Subject: Fw: Planning Consultation on: EG/25/13/

APPLICATION NO: EG/25/13/

Site Address: 1 Hall Cottages Barnham Road Eastergate PO20 3RS

Description of Works: Provision of a drop kerb

DWG Nº DUN 1SP

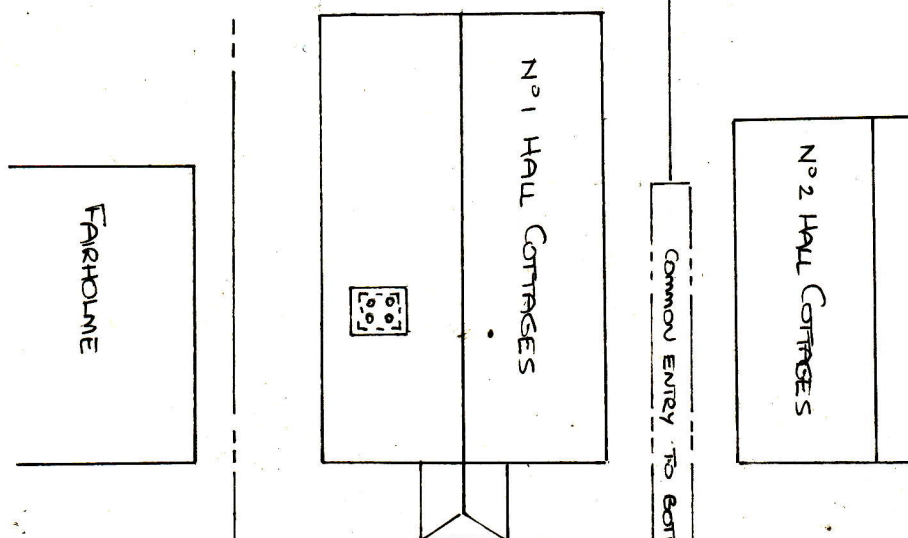
The proposed crossover to access the driveway will require visibility splays of 2m for pedestrians, as shown on the proposed plans; this will require any proposed planting to be no higher than 0.6m above the ground level and any existing foliage to be maintained in order to safeguard the visibility splay.

Vehicular visibility splays of 2.4 by 43 metres have been shown on the submitted plan and appear to be achievable. A licence from the WSCC local Community Highway Officer will be required prior to any access works taking place.

A turn on site would be preferred, clearly though there is insufficient space to achieve this. However other properties have similar arrangements and balanced against this is the benefit of providing an opportunity to remove a vehicle that could otherwise be parked on the highway in a location where the can be on-street parking by residents of adjoining properties. This would result in a noticeable narrowing of the existing available carriageway space.

If the LPA are minded to approve this application a condition securing the new access, pedestrian and vehicle splays should be included.
